The Eggborough CCGT Project

Document Ref: 9.3
PINS Ref: EN010081

**Applicant's Comments on the Local Impact Report, Written
Representations & Responses to the ExA's First Written Questions
- Deadline 3**

Applicant: Eggborough Power Limited
Date: November 2017

Drawing Title
FIGURE 5.2: INDICATIVE GAS SUPPLY PIPELINE CONNECTION WORKS TYPICAL CROSS SECTION OF CONSTRUCTION CORRIDOR

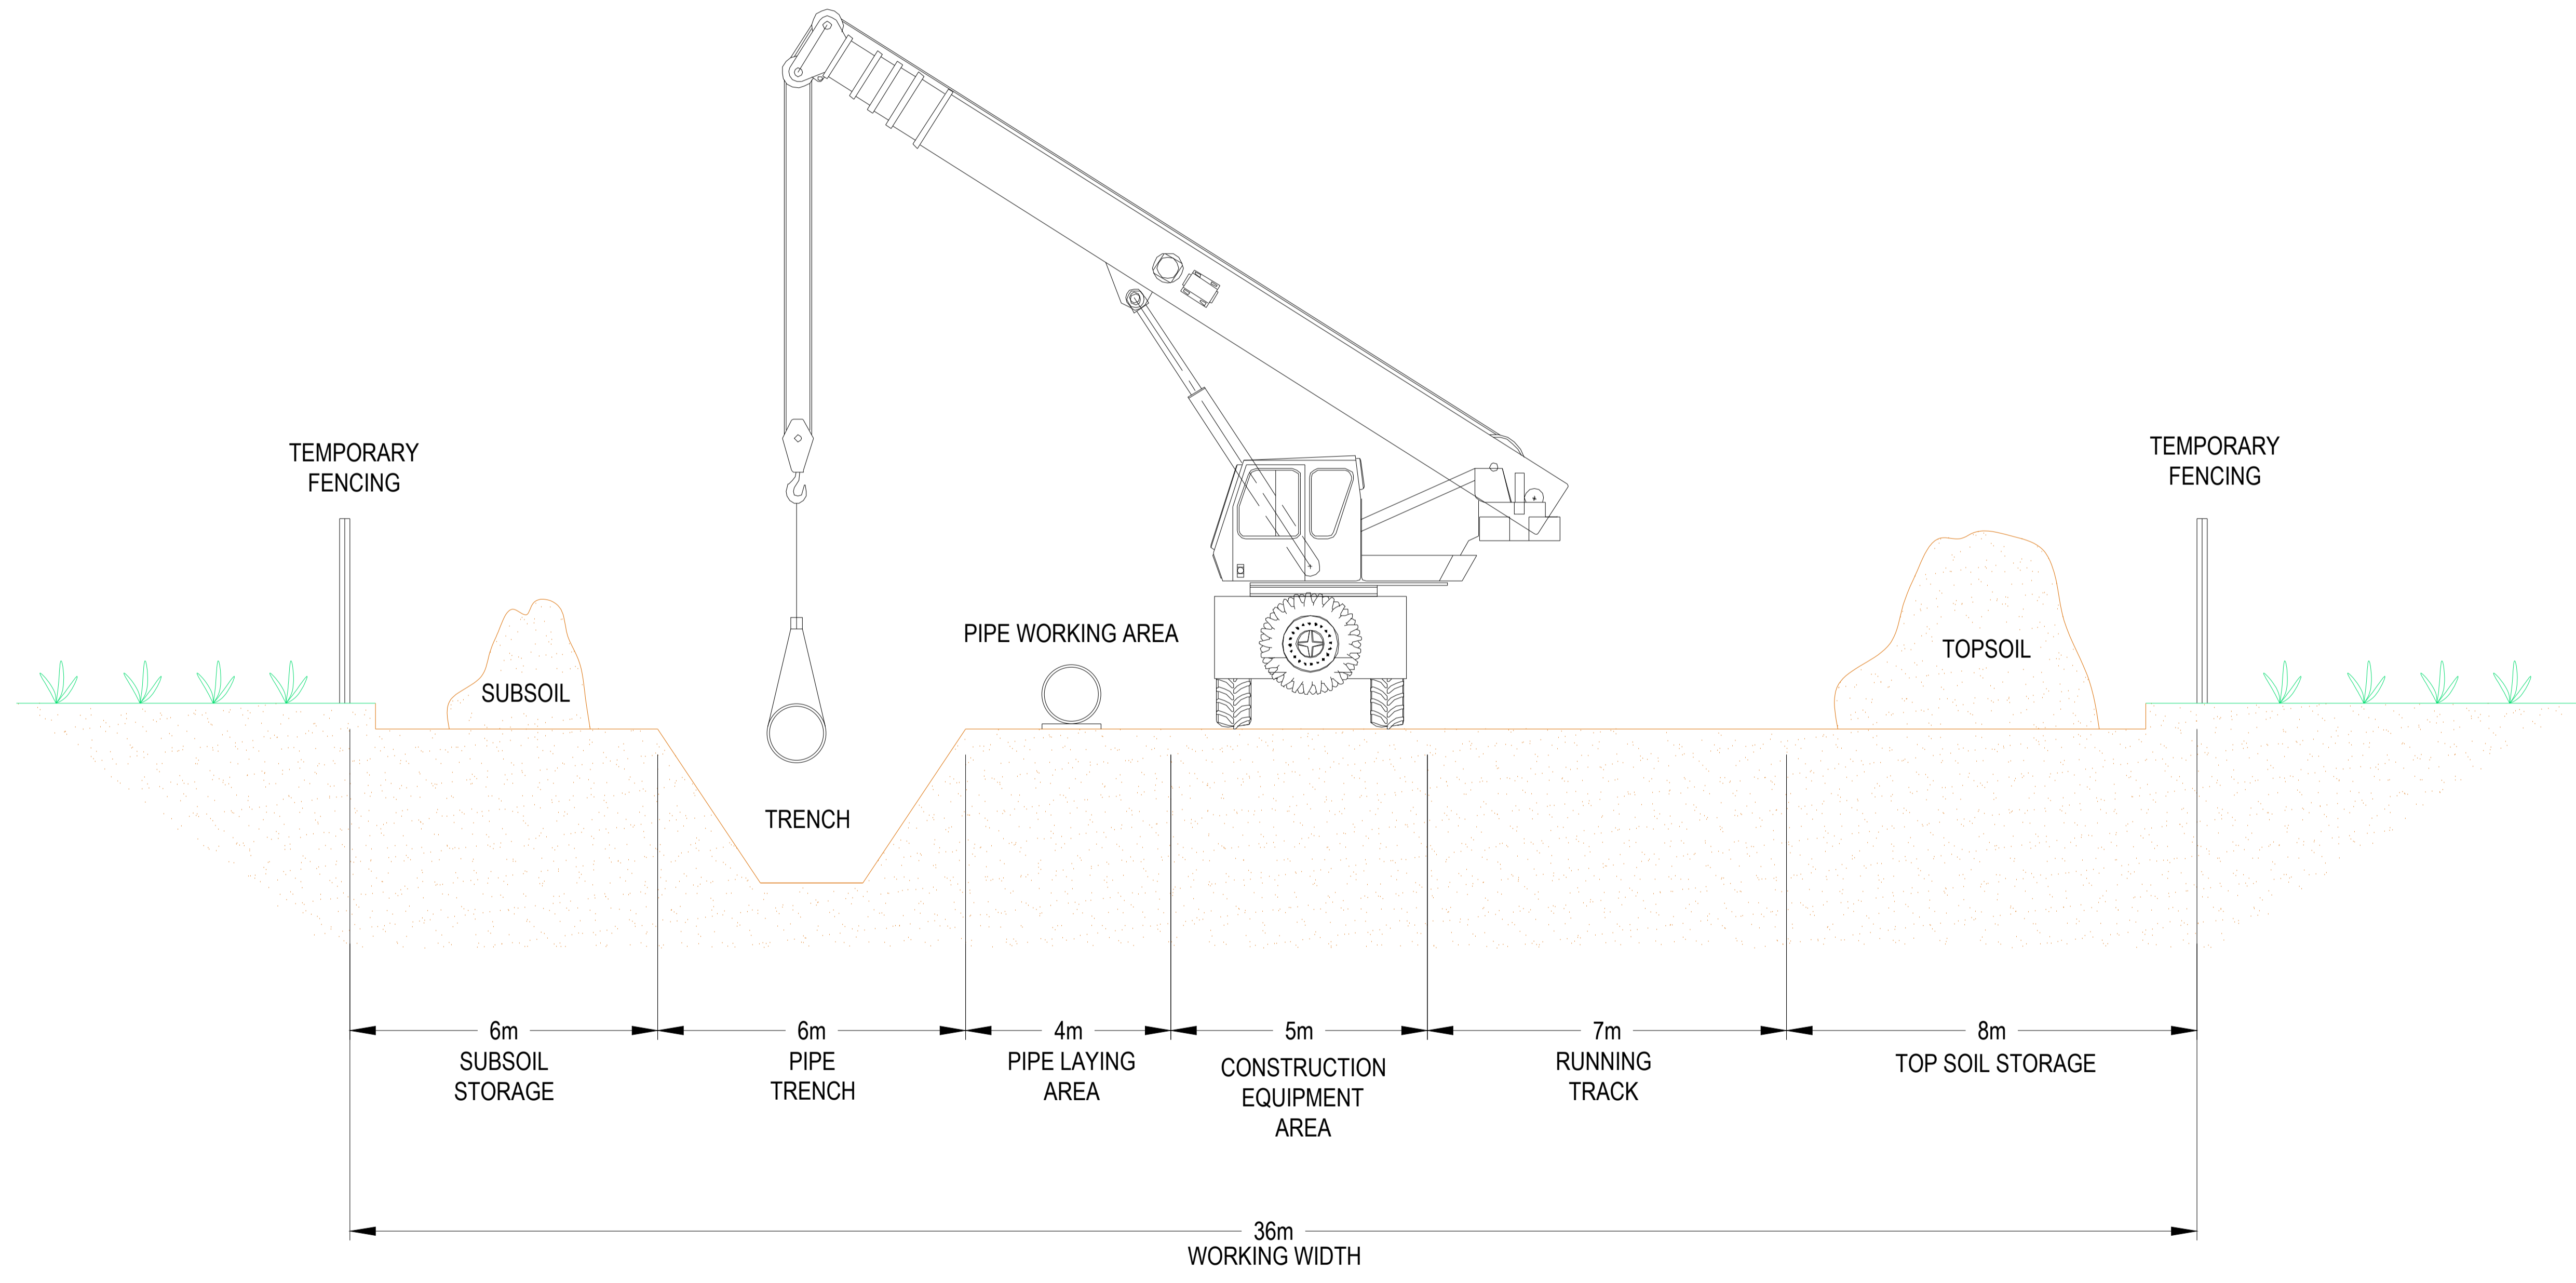
19.	EA	Written Representation - paragraphs 8.2 - 8.3, 'Pipeline Crossing of the River Aire and Flood	Concern regarding the pipeline crossing of the River Aire and the integrity of the EA's flood defences.	The EA has raised concern about the method proposed to construct the Proposed Gas Connection under the River Aire and through flood defences either side of the River. This concern related to the effect that an open-cut method may have on the EA's flood defences, if used.

Ref.	Interested Party	Document & Reference	Summary of Issue/Matter	Applicant's Comments/Response
		Defences' ExA FWQ FW 1.16 'River Aire Crossing'		<p>The Applicant has proposed that it will use horizontal directional drilling ('HDD') under the River and to extend this underneath the flood defences to the north and south of the River. This is secured by Requirement 5 'Detailed design', sub-paragraph (8)(d) of the draft DCO (Document Ref. 2.1 - Rev. 2.0 submitted at Deadline 2), which requires the approval of the relevant planning authority to the route and method of installation of the pipeline. The Applicant also amended the wording of sub-paragraph (8)(d) for Deadline 2 to include the EA as a consultee and require the following details to be approved in consultation with it:</p> <p><i>"(d) the route and method of installation of the high pressure steel pipeline and any electrical supply, telemetry and other apparatus, including under and within the footprint of any flood defences;..."</i></p> <p>While HDD is likely to offer a preferable construction method for the Proposed Gas Connection within the vicinity of the EA's flood defences, the EA has confirmed that it will require safeguards in the form of settlement monitoring, which will ensure that the works do not affect its flood defences. In order to secure this, the Applicant has agreed to include the following new requirement within the revised draft DCO (Document Ref. 2.1 - Rev. 3.0) submitted for Deadline 3:</p> <p><i>"40-(1) Prior to commencement of Work No. 6, a scheme for monitoring ground subsidence in and around the flood defences for the River Aire must be submitted to and, following consultation with the Environment Agency, approved by the relevant planning authority.</i></p> <p><i>(2) The scheme must set out:</i></p> <p><i>(a) the details of the work which is to be subject to monitoring;</i></p> <p><i>(b) the extent of land to be monitored;</i></p>

Ref.	Interested Party	Document & Reference	Summary of Issue/Matter	Applicant's Comments/Response
				<p>(c) the manner in which ground levels are to be monitored; (d) the duration of monitoring activities; and (e) the extent of ground subsidence which, if exceeded, will require the undertaker to submit a ground subsidence mitigation scheme for the Environment Agency's approval in accordance with sub-paragraph (3).</p> <p>(3) If the monitoring identifies that ground subsidence has exceeded the level described in subparagraph (2)(e), a scheme setting out mitigation measures in relation to the ground subsidence must be submitted as soon as is reasonably practicable to and, following consultation with the Environment Agency, approved by the relevant planning authority.</p> <p>(4) The mitigation scheme approved pursuant to sub-paragraph (3) must be implemented as approved, unless otherwise agreed in writing with the relevant planning authority."</p> <p>The agreement that has been reached between the Applicant and EA on this matter is set out at Section 5 of the SoCG between the parties (Document Ref 7.3 - Rev. 3.0) submitted for Deadline 3.</p>

INDICATIVE COFFERDAM ARRANGEMENT
(COOLING WATER DISCHARGE POINT)

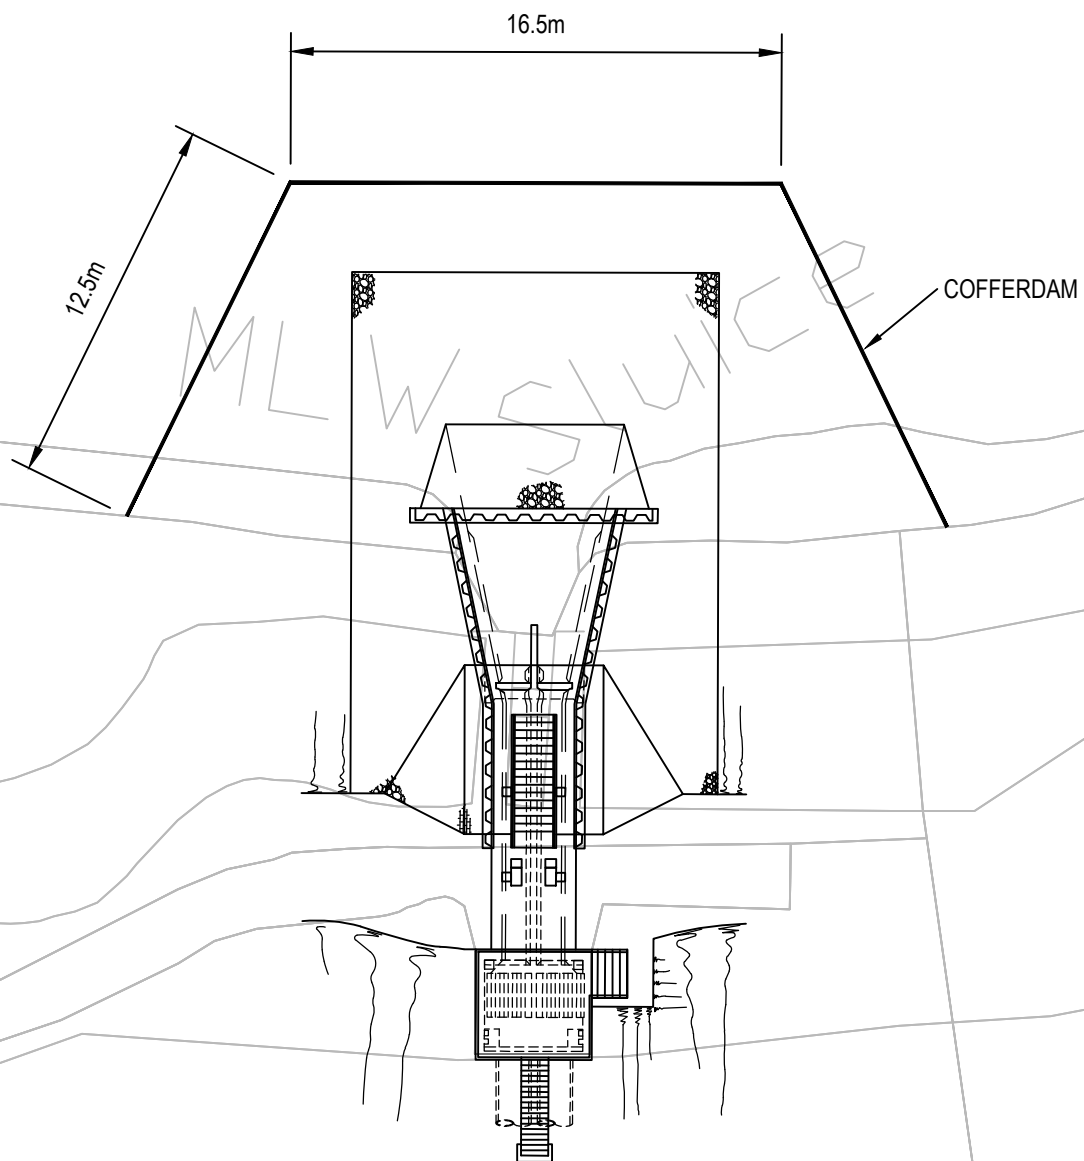
22.	CRT	Written Representation - 'Proposed Abstraction from the River Aire and Proposed Construction in the River Aire'	<p>CRT should be a consultee to the proposed condition at Schedule 2, paragraph 5(6) of the draft DCO.</p> <p>The extent and location of cofferdams will have a direct impact on navigational activities on the River. The CRT request that it is consulted as part of the requirements, as this is necessary to ensure that the impact of the cofferdams on</p>	<p>Requirement 5(6) specifies that the CRT is required to be consulted in respect of Work No 4.</p> <p>In response to the CRT's point regarding consultation on the cofferdam proposals, the effect of their inclusion as a consultee in Requirement 5(6) is that they are required to be consulted on the detailed design of Work No 4 as a whole. The Applicant considers that the drafting of Requirement 5(6)(a)-(c) ensures that CRT would be consulted on cofferdams (generally) and in respect of the extent and location of the cofferdams (pursuant to Requirement 5(6)(c) specifically).</p> <p>The Applicant does not consider that any further amendments are required to Requirement 5(6) on this basis.</p>

Ref.	Interested Party	Document & Reference	Summary of Issue/Matter	Applicant's Comments/Response
			navigation can be fully considered.	
23.	CRT	Written Representation - 'Protective Provisions'	Protective Provisions included at Schedule 12 of the draft DCO and Inclusion as a named body in Schedule 2	<p>The Applicant and CRT are in discussions on the form and content of the protective provisions to be included in the draft DCO.</p> <p>In the revised draft DCO submitted for Deadline 3, the Applicant has included a set of provisions it considers are appropriate to protect the interests of CRT.</p> <p>There are some areas of disagreement between the parties, as discussed during the Hearing on Compulsory Acquisition (23 November 2017). To assist the ExA, a summary of the main points not yet agreed are provided below. In addition to these, there are some additional, more minor points which the Applicant is discussing with CRT. It is the intention of the Applicant to continue to negotiate with CRT with a view to reaching agreement on these outstanding points.</p> <ul style="list-style-type: none"> • Abstraction: as explained above, the form of wording put forward by the CRT in this respect is not agreed however the parties are in discussions regarding a variation to the drafting proposed. • Expenses: the Applicant has proposed wording which would allow them to review any Expenses as they arise and afford them the opportunity to reduce or further mitigate the need for those costs. The Applicant considers that this would be a fair and reasonable approach for both parties. CRT has confirmed that this drafting is not accepted but has not provide an explanation as to why • Indemnity: The Applicant has proposed to limit its indemnity to £5 million (which is commensurate with the insurance required by CRT). This cap is not accepted by CRT, which is seeking an unlimited indemnity. It is the Applicant's position that it is not reasonable or proportionate, given the nature of the works, to seek an indemnity on this basis, and that the cap
